Please ask for: Ms Iqraa Malik
Email: iqraa.malik@terraquest.co.uk
Telephone: 01212341390
Our Ref: AW/170/20/HH
Your Ref:
Date: 23rd July 2020

Application for Planning Permission for Works or Extension to a Dwelling

Development: Drop kerb
Location: 116 Nyetimber Lane Aldwick PO21 3HL

Block Plan shows area bounded by: 489971.95, 98709.96 490061.95, 98799.96 (at a scale of 1:500), OSGridRef: SZ90019875. The representation of a road, track or path is no evidence of a right of way. The representation of features as lines is no evidence of a property boundary.

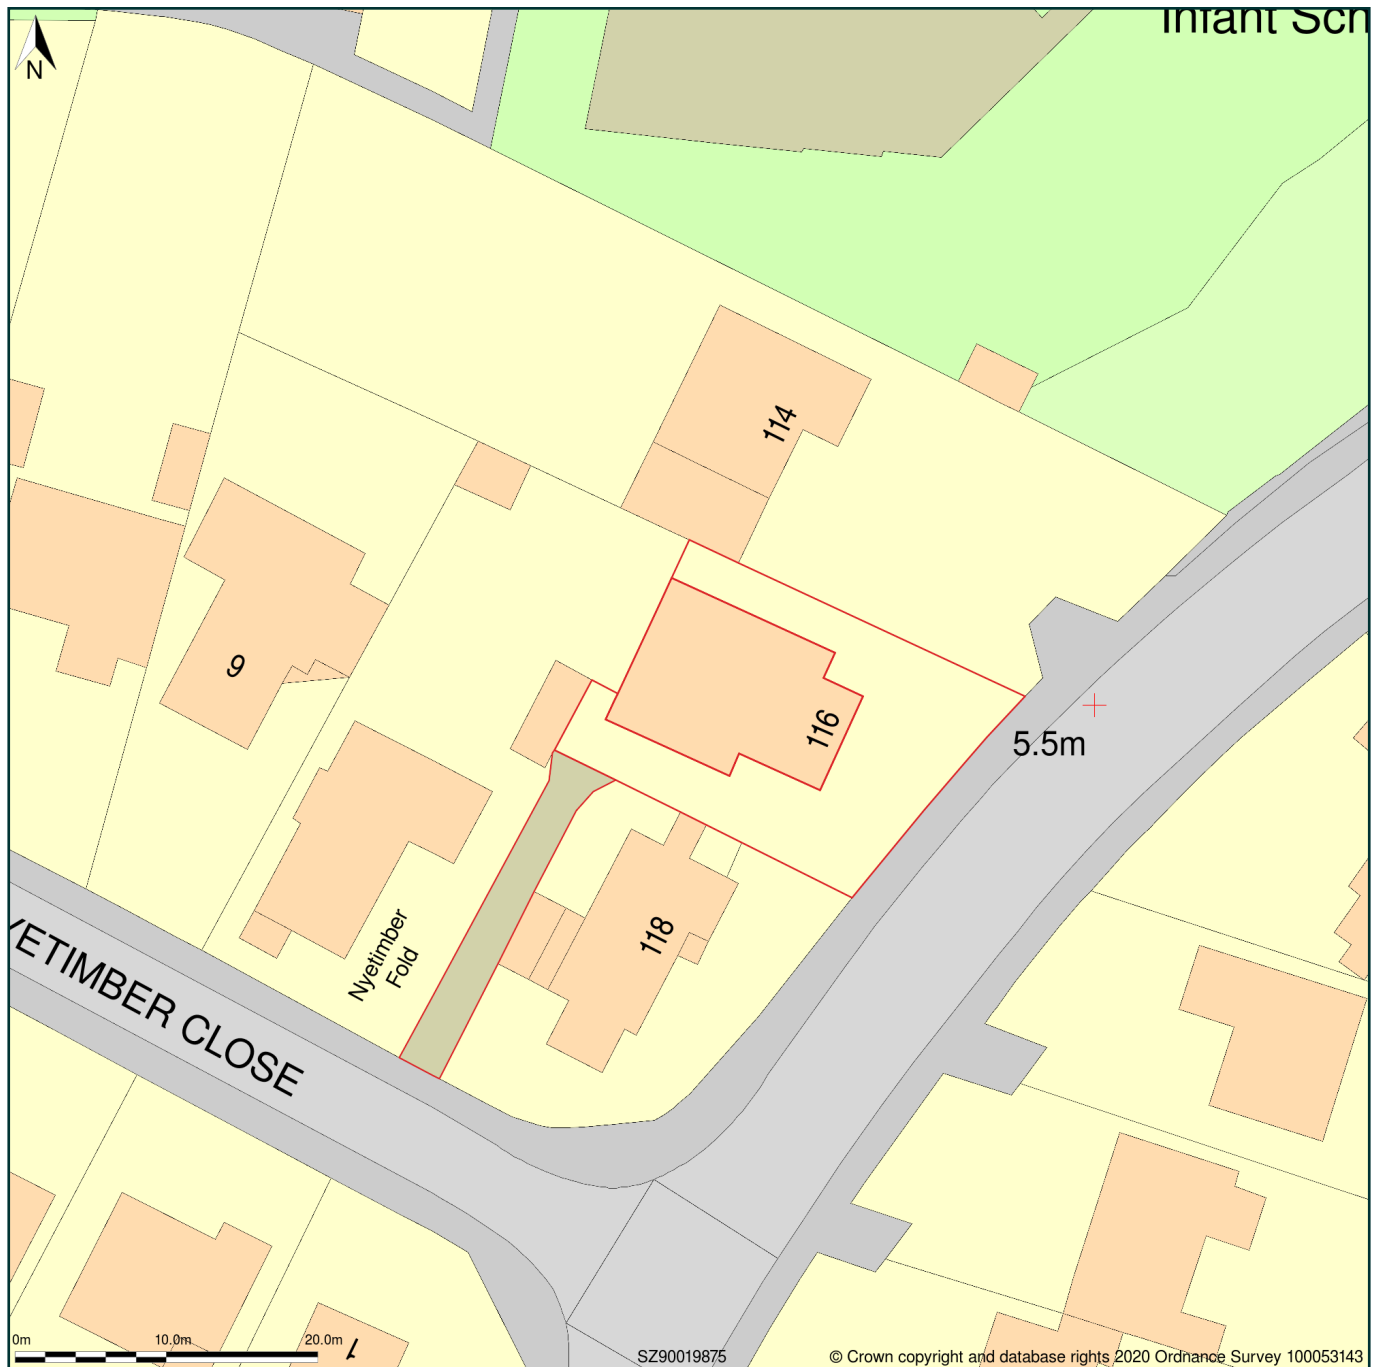
The scale bar and the visibility splays displayed on the block plan don't measure to scale. Please amend.
